From: Laura Gibbons <Laura.Gibbons@arun.gov.uk>
Sent: 19 April 2022 14:25
To: Planning.Responses <Planning.Responses@arun.gov.uk>
Cc: Simon Davis <Simon.Davis@arun.gov.uk>
Subject: RE: Planning Re-Consultation on: AL/28/22/DOC

Engineers Comments Regarding Condition 10

Application No: AL/28/22/DOC

Description of Works: Approval of details reserved by condition imposed under AL/20/21/PL relating to condition 10-surface water drainage. Decision due 28.04.22

ATTENUATION BASIN

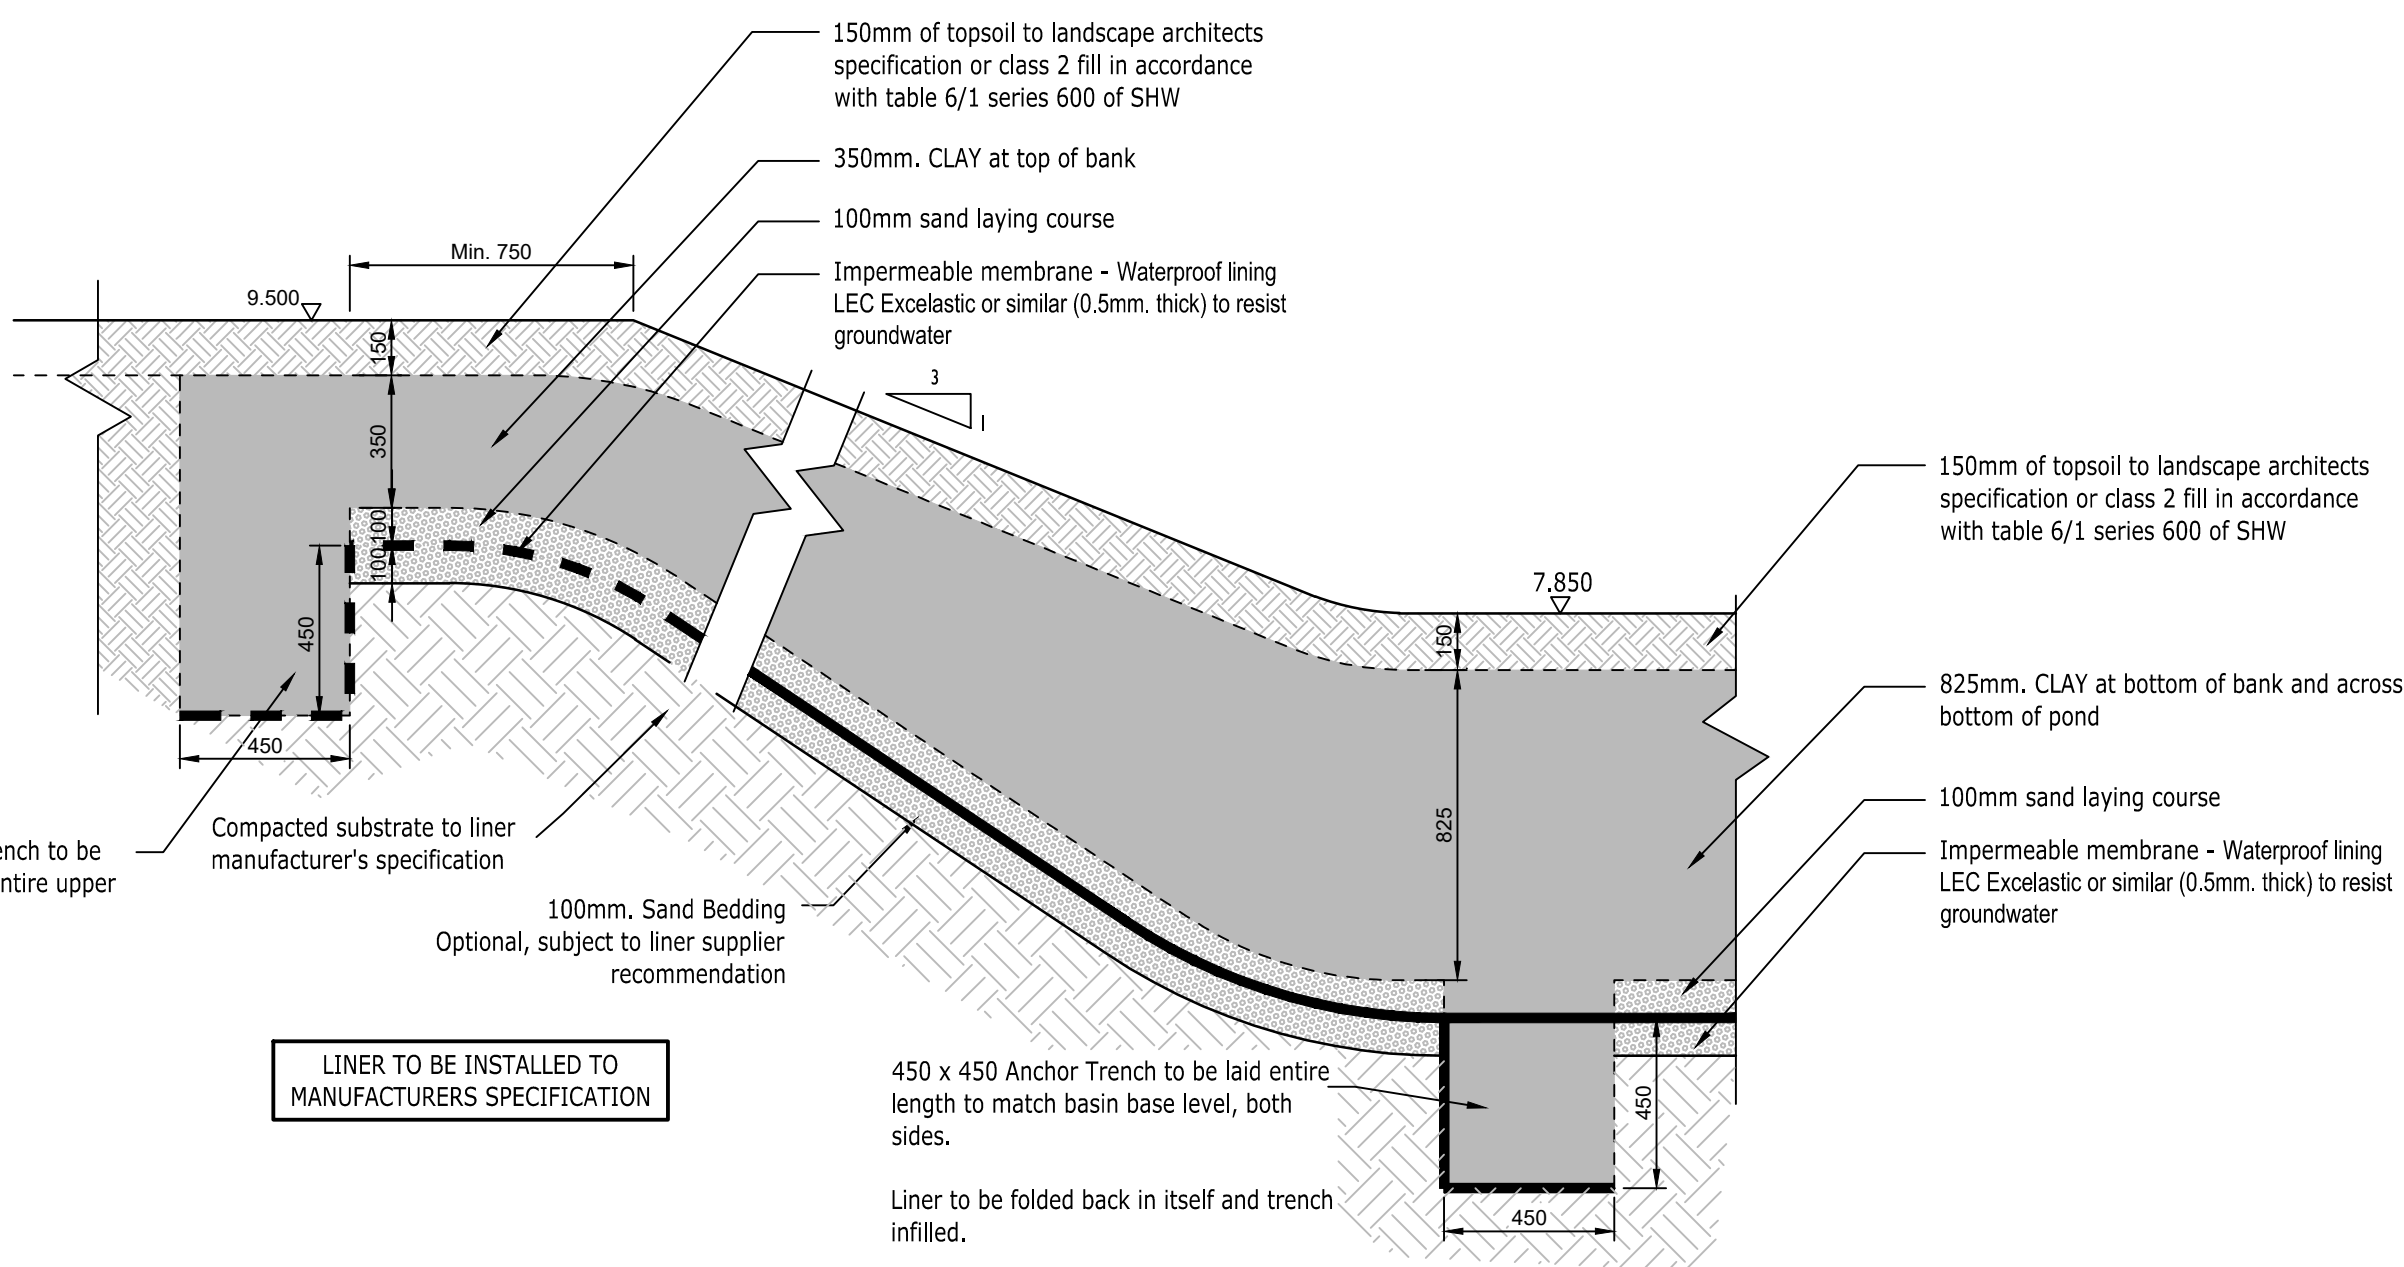
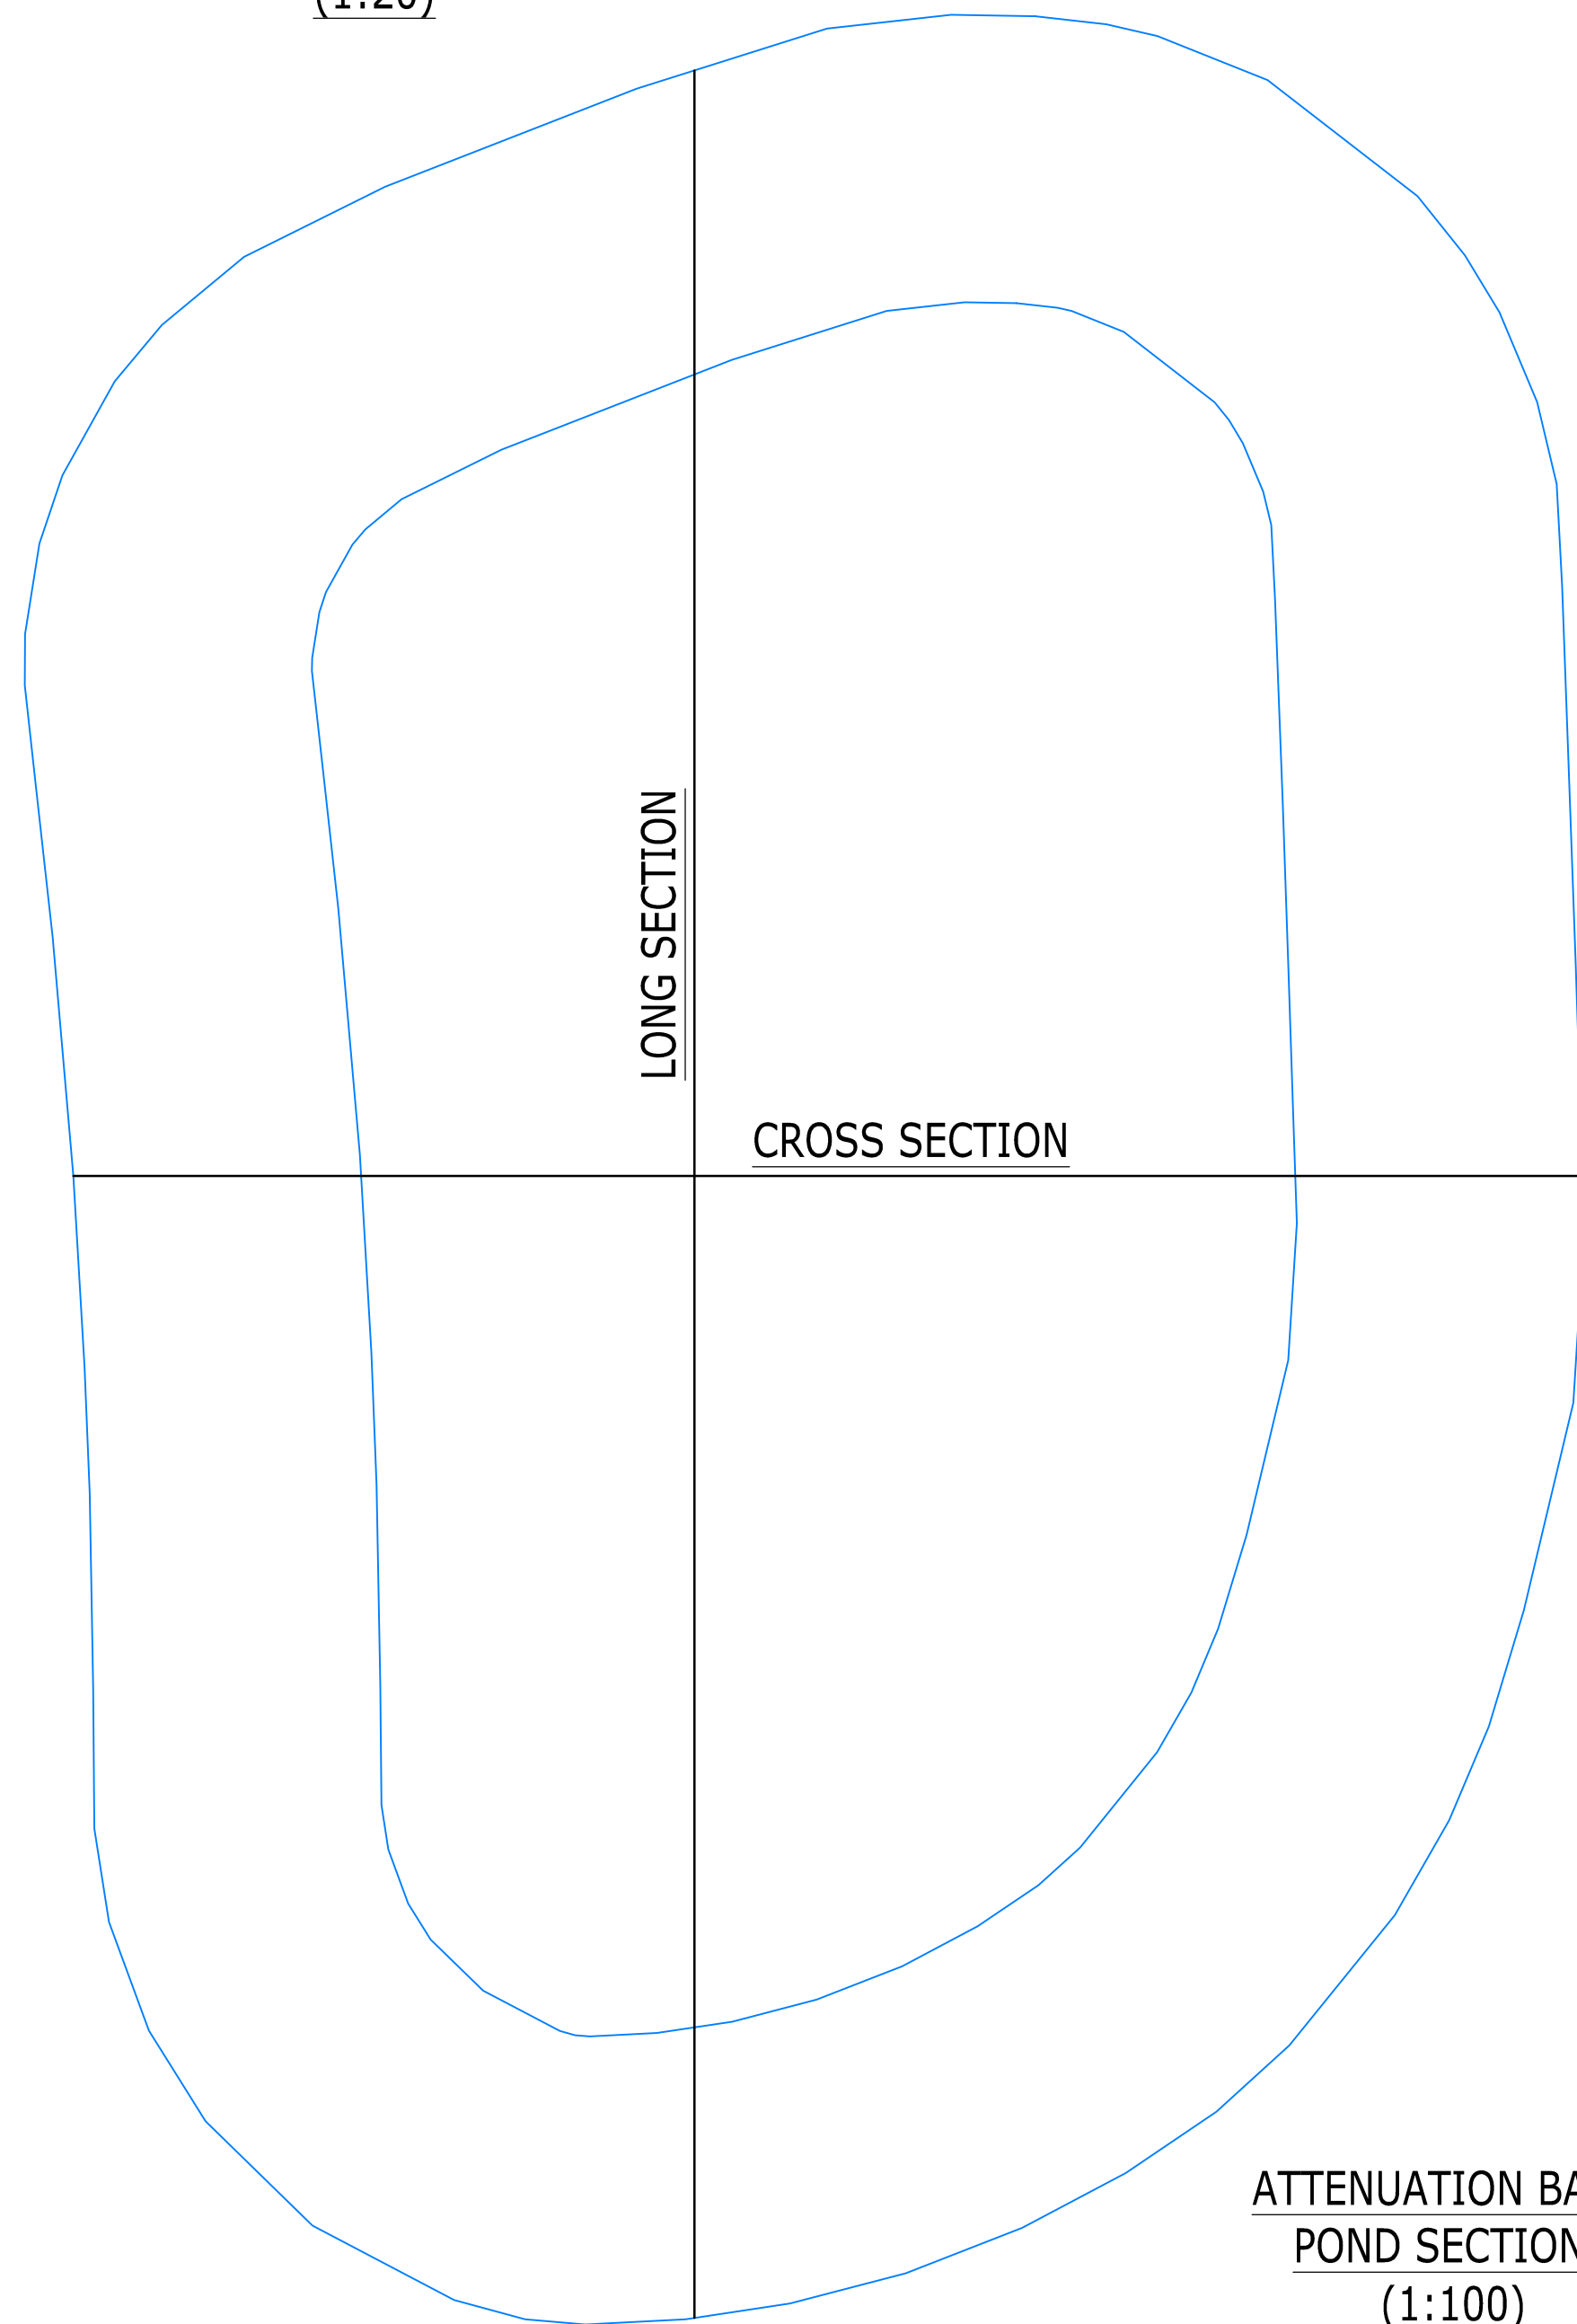
12. Please provide flotation calculations for cellular storage and attenuation basin. *Calculations provided, however no groundwater data near basin. Assumed depth of groundwater requires discussion and agreement.*

16. Please provide construction detail drawings of permeable paving. *Okay.*
17. Please provide two perpendicular cross sections of the basin, please detail liner, topsoil depths, etc. on construction detail drawing. *See comment 12.*
